Recommendation Report for Planning Permission for Works or Extension to a Dwelling

REF NO: FP/206/21/HH

LOCATION: 10 Old Manor House Gardens
Felpham
PO22 8QR

PROPOSAL: Single storey front porch/garage extension

Title
Proposed Elevations

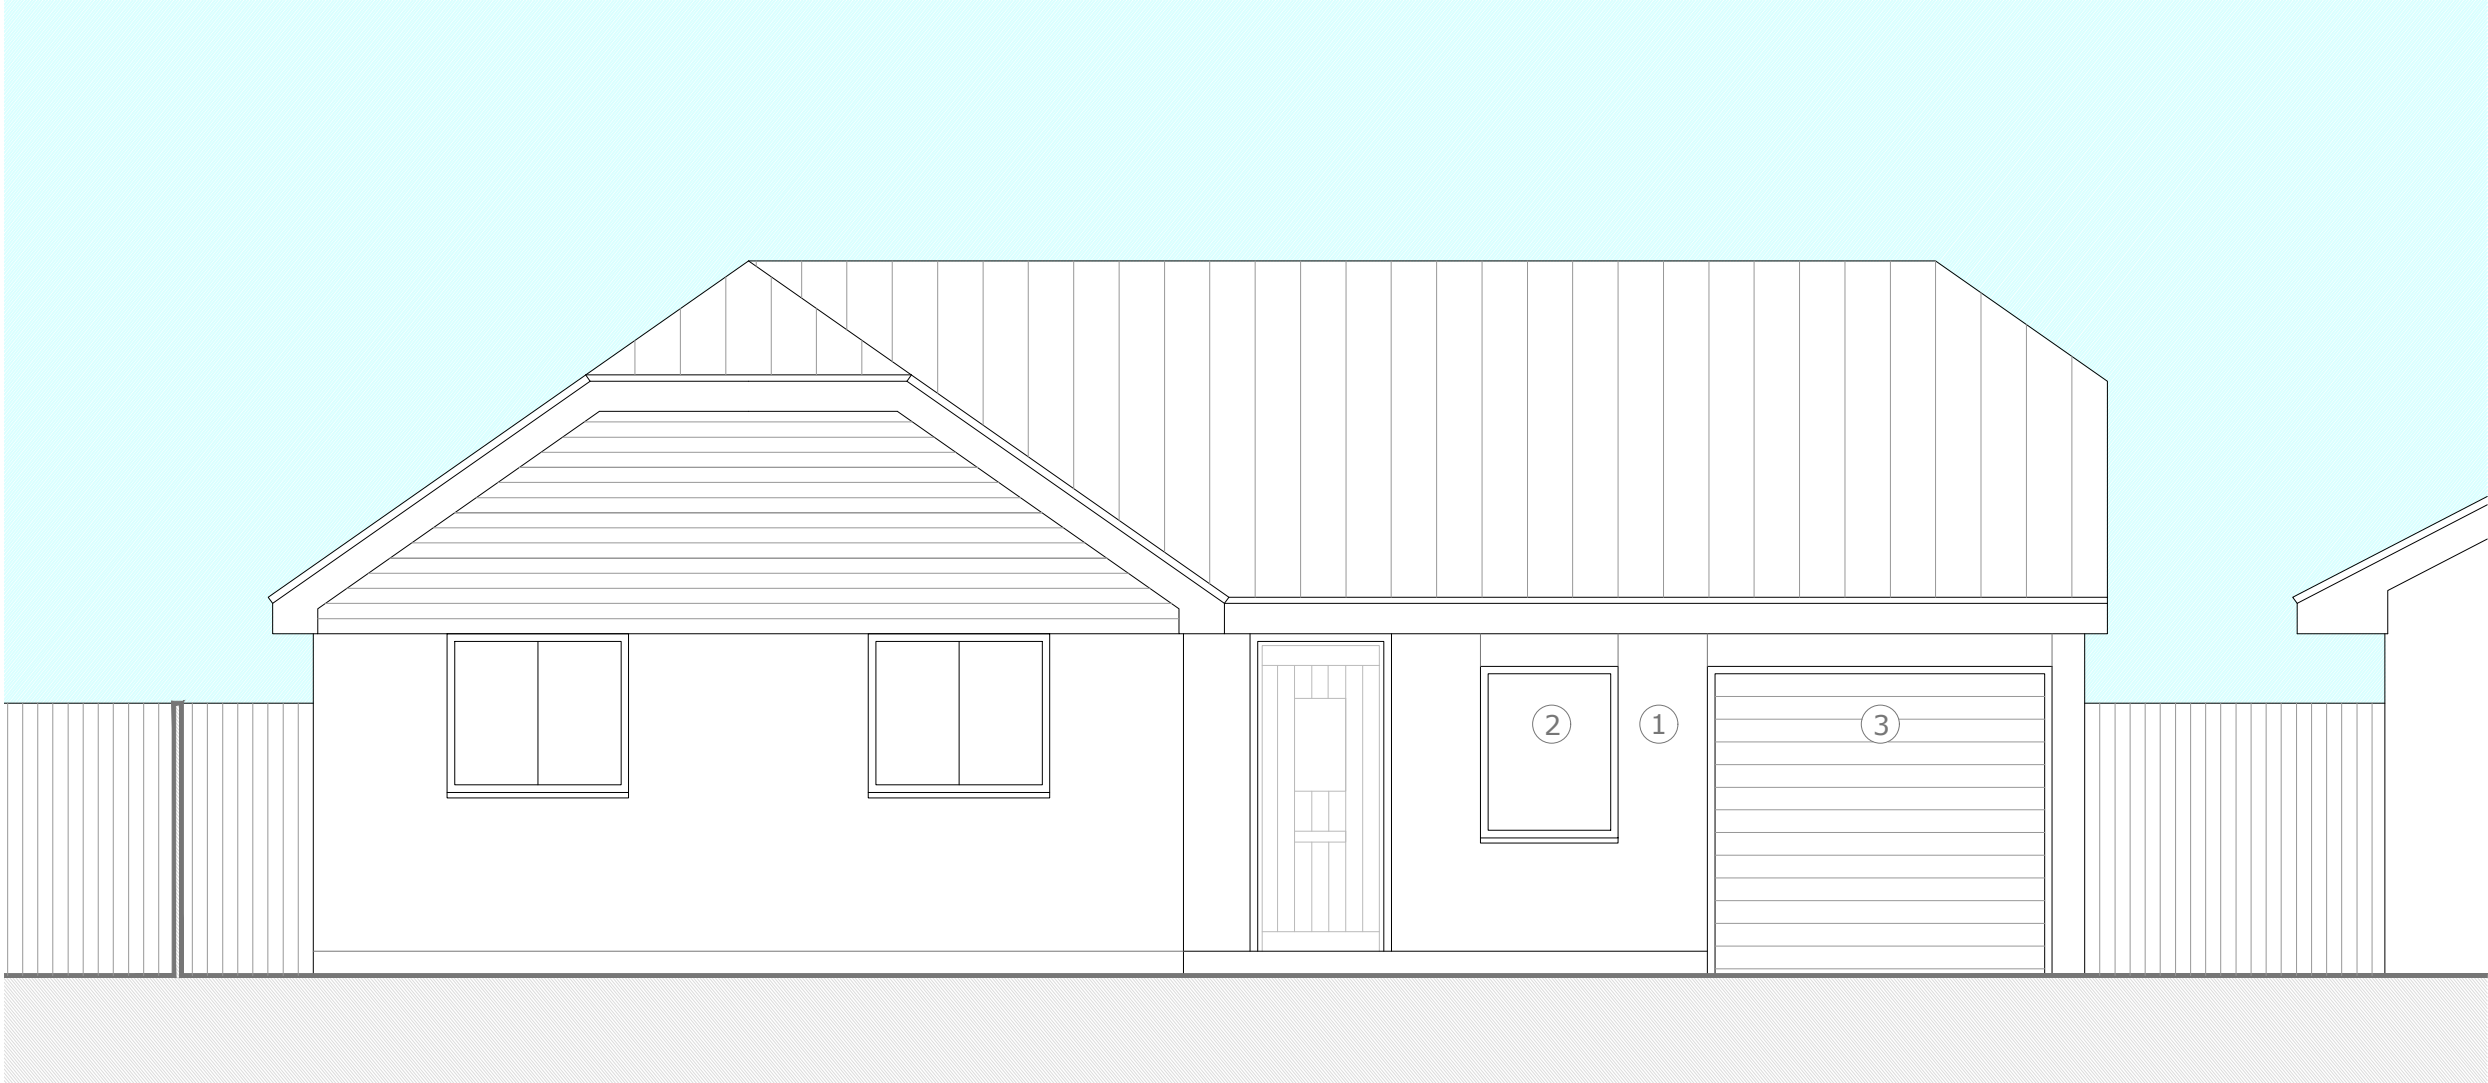
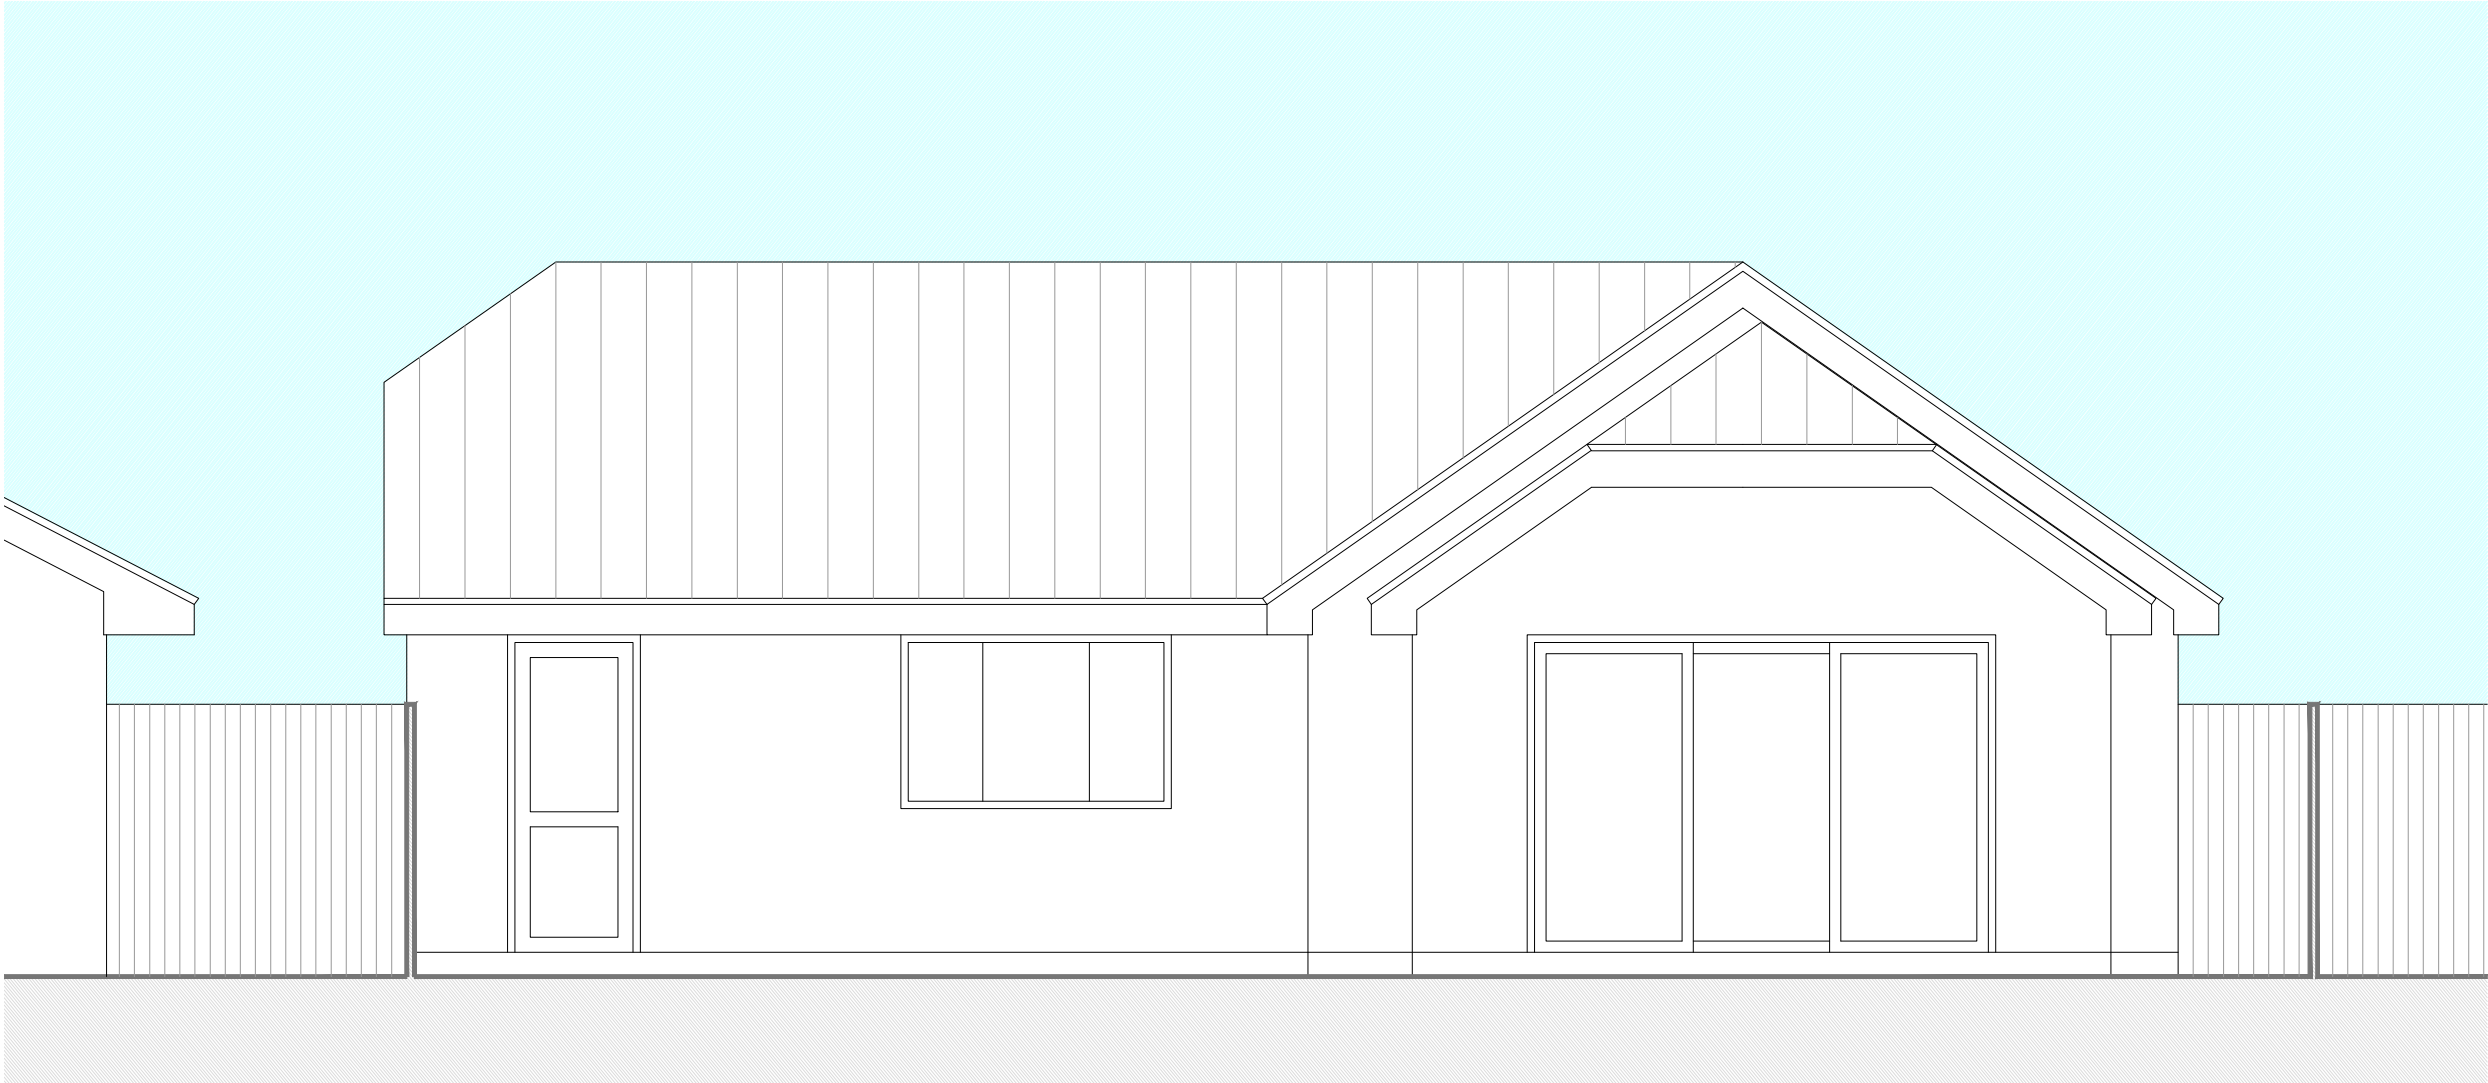
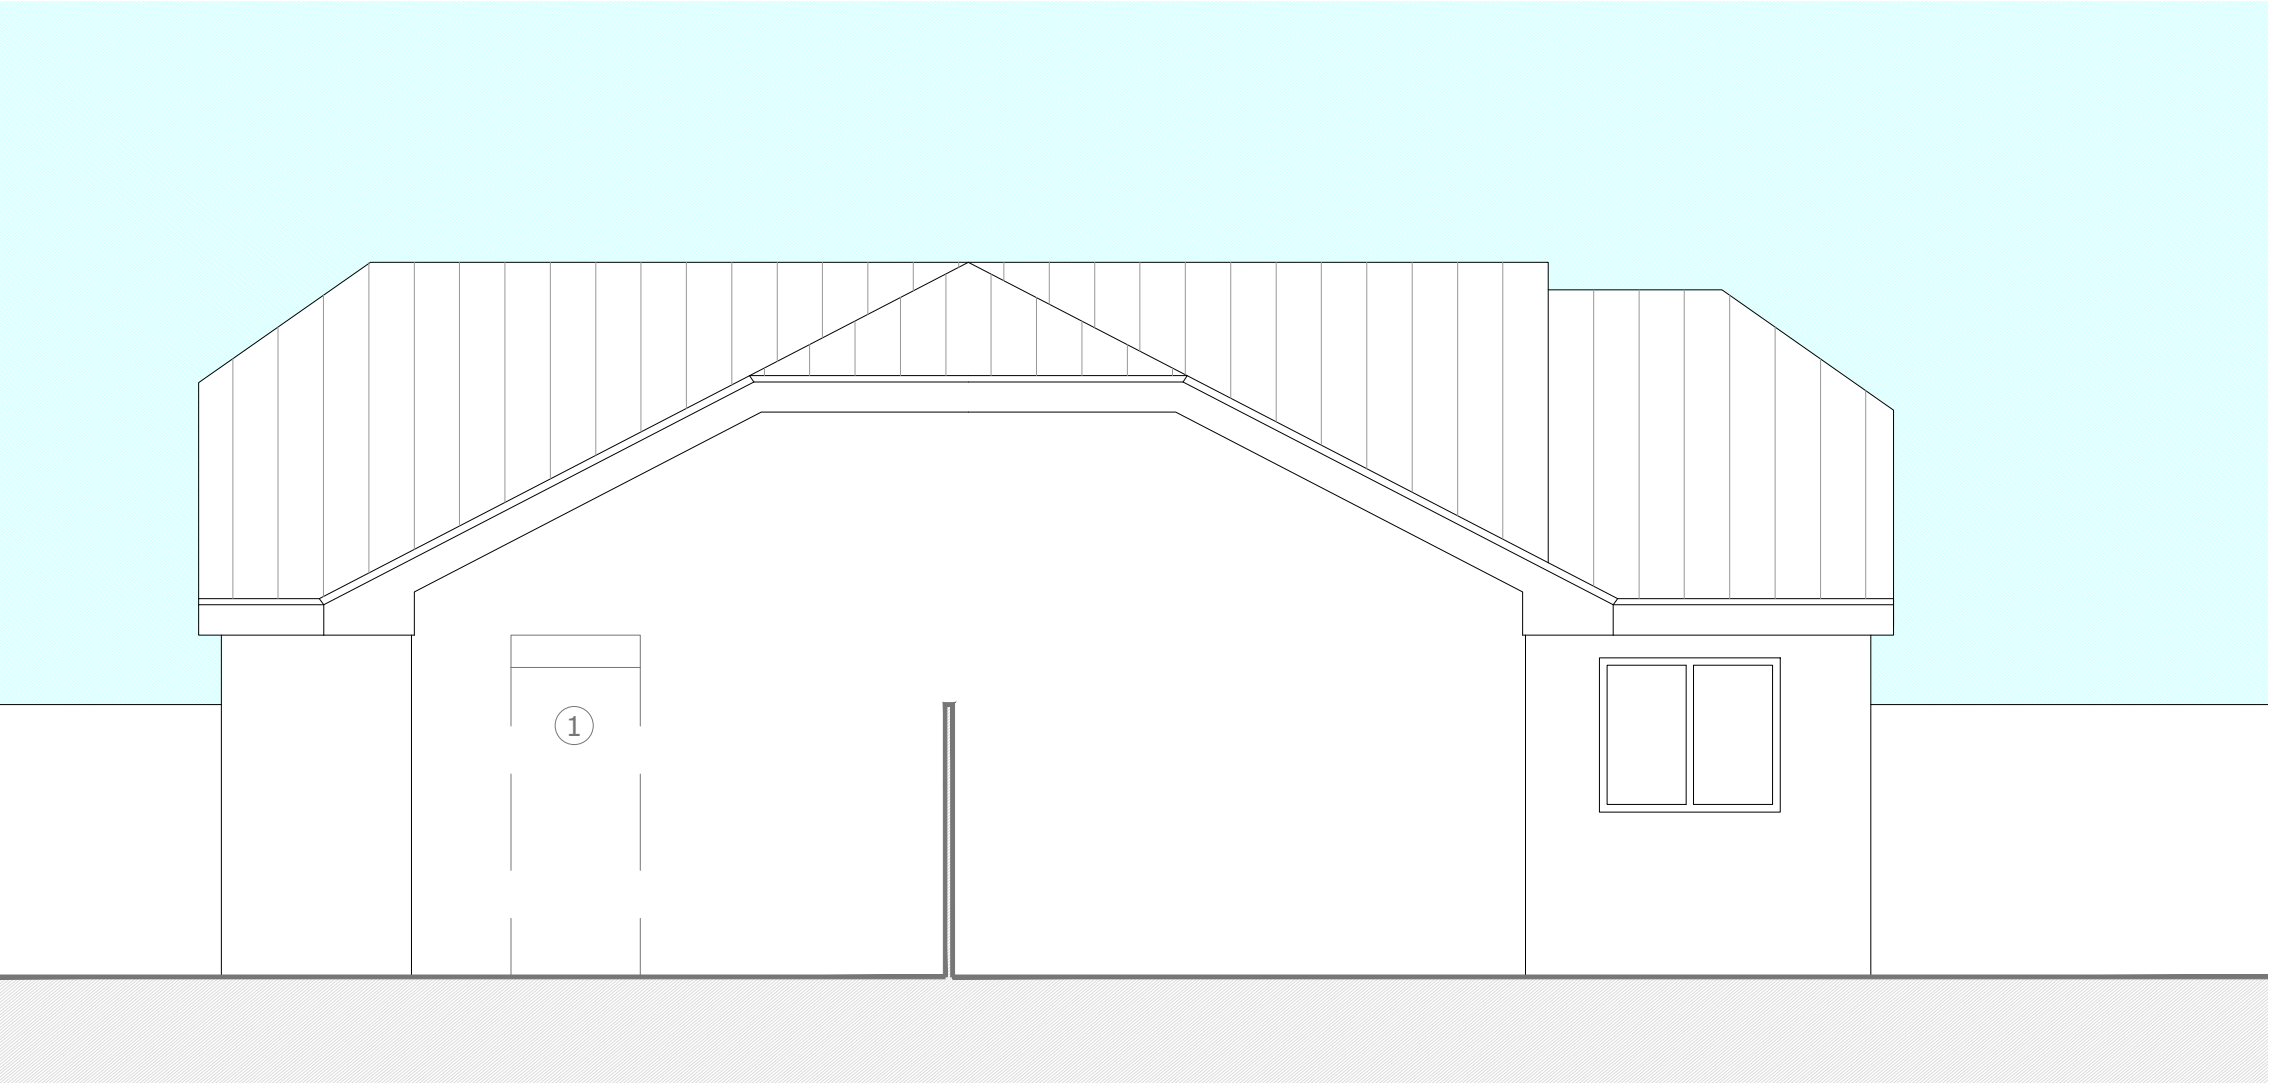
There is a covered area which runs along the front of the dwelling forming an open porch. The proposal seeks to enclose this and the development does not extend beyond the existing principal elevation. This has a depth of approximately 1.65m which meets with the gable front.

The development is minor in nature and largely retains the appearance of the dwelling. External materials match the host dwelling which ensures the appearance of the porch extension remains sympathetic with the dwelling. There is a window and garage door and the proposal will retain these.

The porch extension will have a depth of 1.65m and a height of 2.45m. This meets with the eaves and the height of the existing covered roof.

The existing openings will be retained with a front door, window and garage door and will front the street scene, thus not proving overlooking upon amenity.
